**Post Point CHN 215**  
**Hertfordshire County Council**  
**County Hall, Pegs Lane**  
**HERTFORD SG13 8DN**

Date 08 June 2018

**RE: 6/2018/1338/FULL – Premier Inn, Stanborough Road, Welwyn Garden City, AL8 6DQ**

Proposed Site Plan

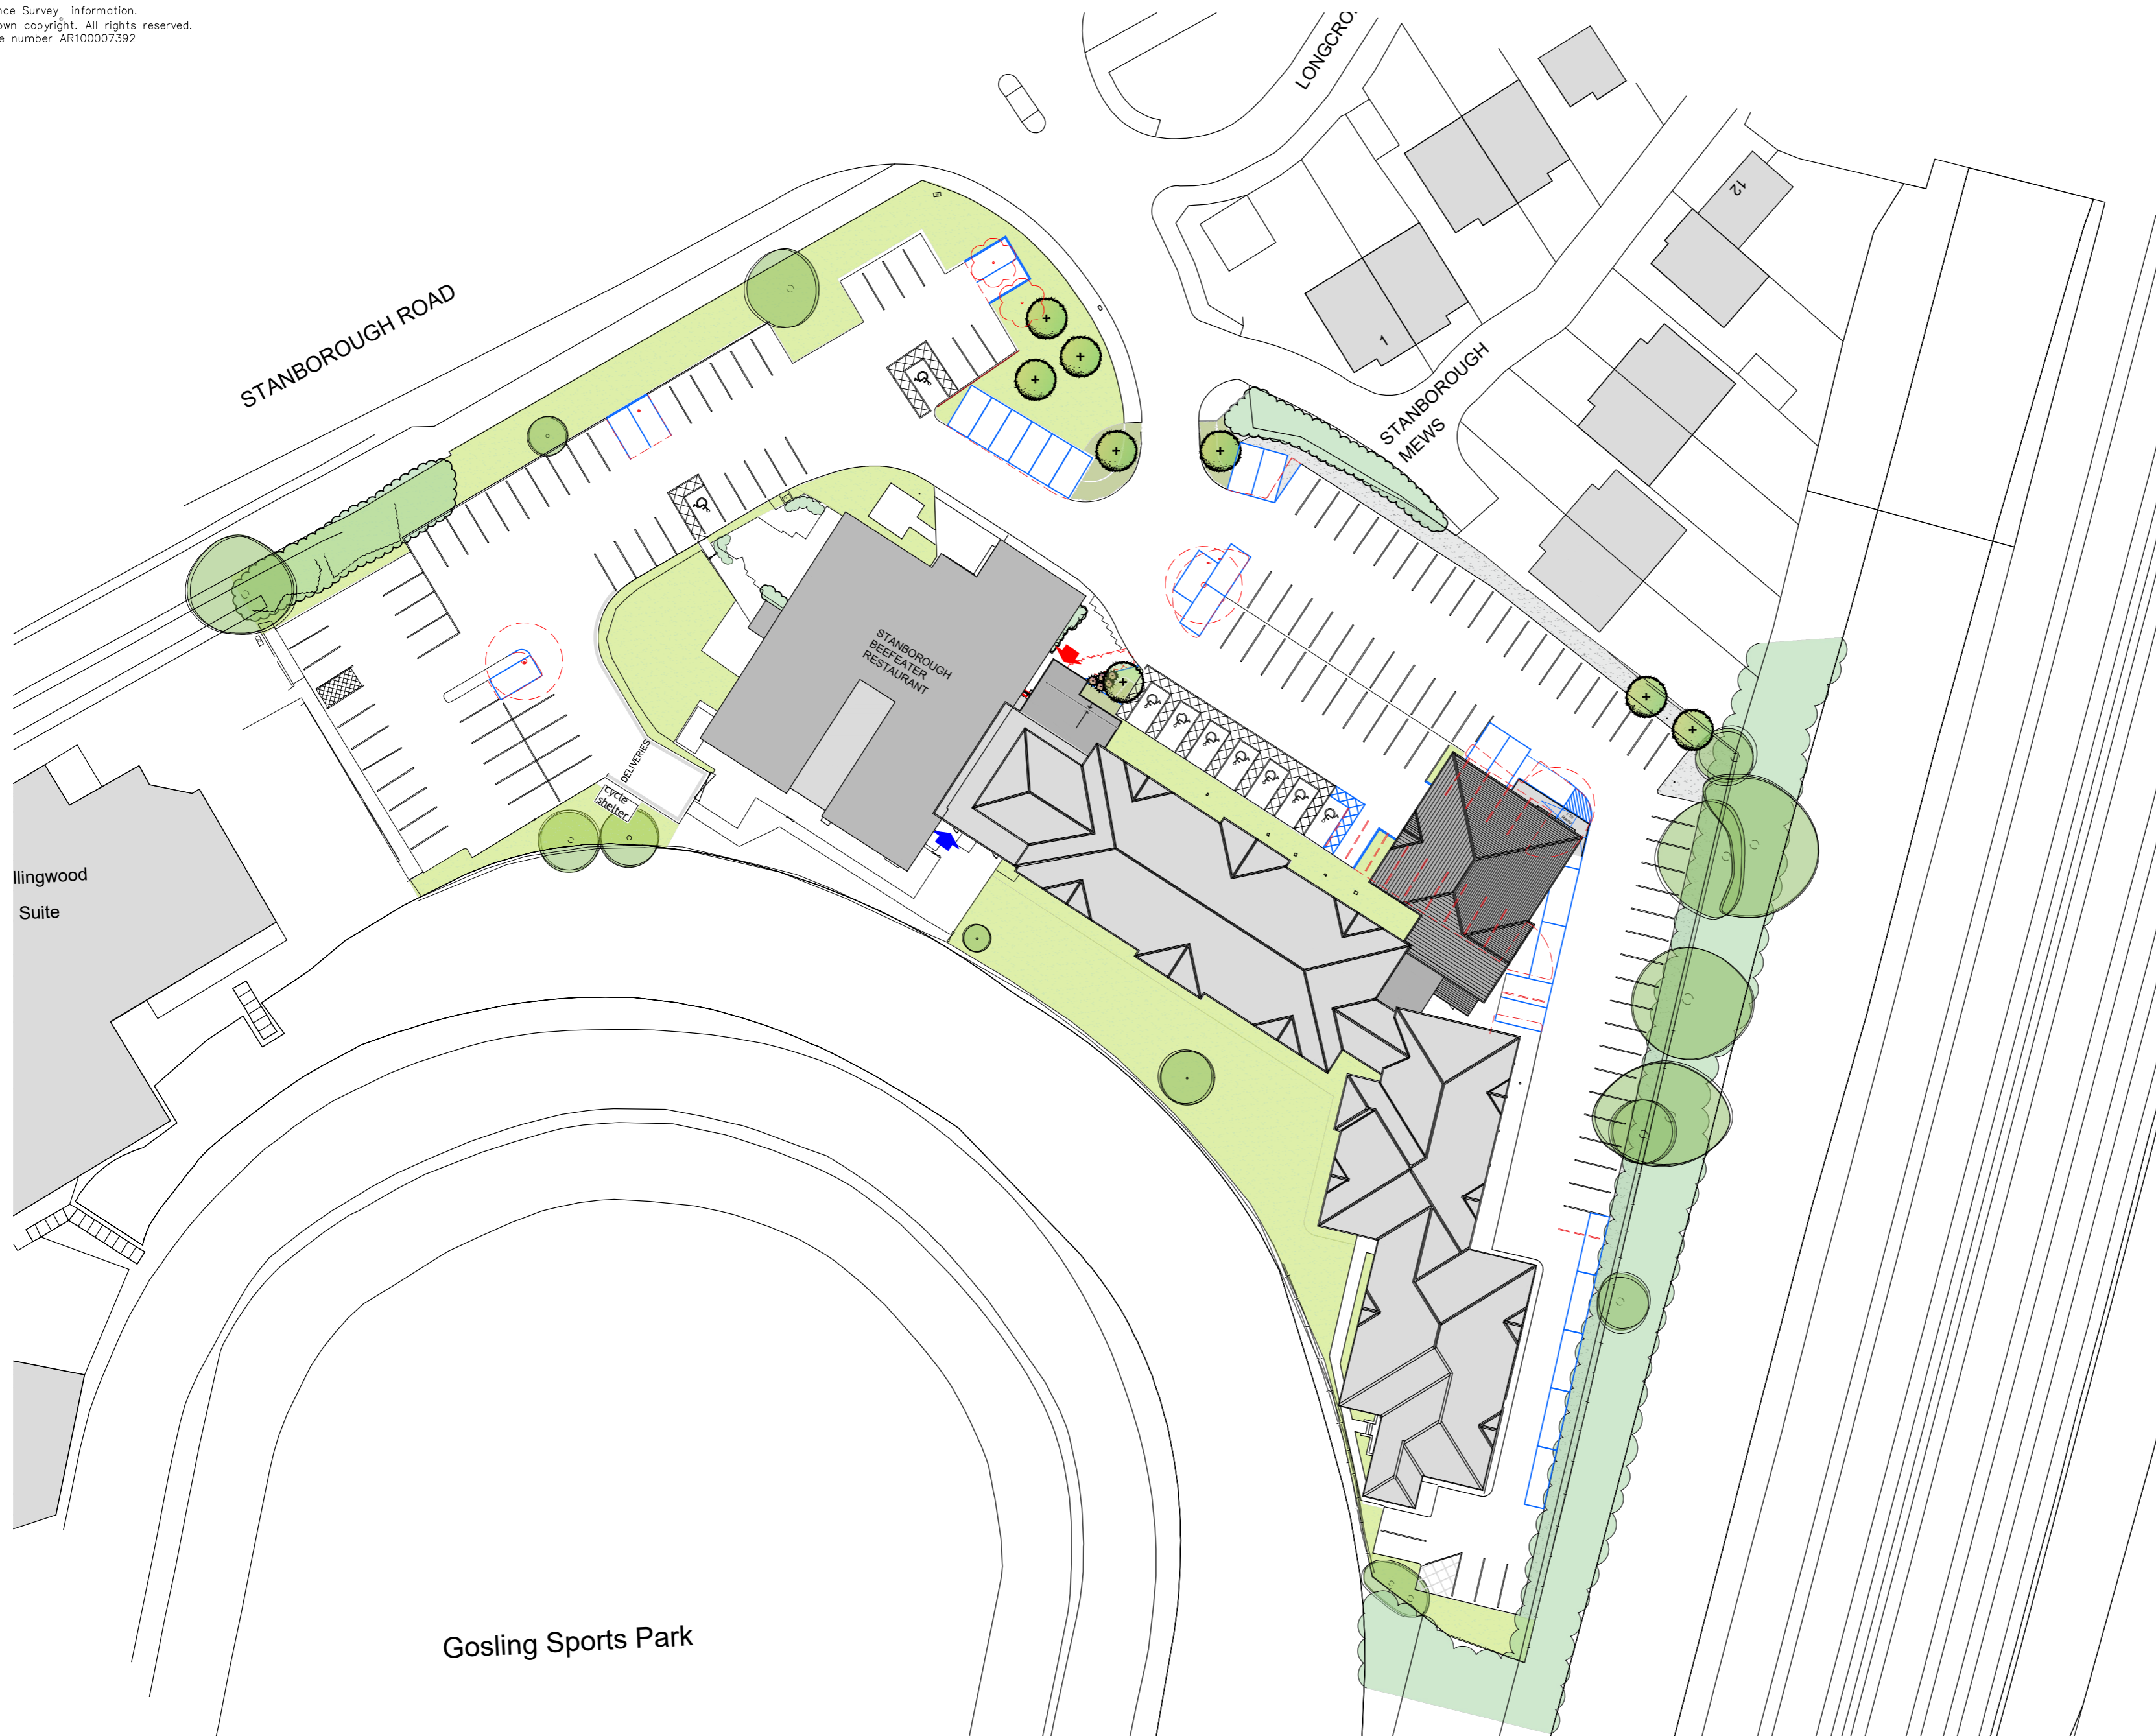
1. We note the applicant has proposed to drain the developed part of the site only. This would include underground tank restricted to discharge of 1.4 l/s into the existing surface water drainage network on site. It should be clarified where this network is connecting.

However, all drainage arrangements for the entire development site should be included within the drainage layout. This should include the existing drainage network on site and all connection points into the wider drainage system. The attenuation volume provided within the system should be indicated on the drawing as well.

Our requirement for a drainage strategy is to demonstrate that no flooding of the site should occur at or below the 1 in 30 year event and any informal flooding of the site above this should be safely contained within the site with no flooding to property or buildings. If areas are to be designated for informal flooding these should also be shown on a detailed site plan.

3. Routes of exceedance will also need to be assessed and identified on a drawing for rainfall events that exceed the 1 in 100 year plus climate change event.
4. The applicant will need to satisfy the LPA that the proposed drainage scheme can be adopted and maintained for its lifetime by providing a maintenance plan, detailing key operations and management. The maintenance of soakaways and the cellular
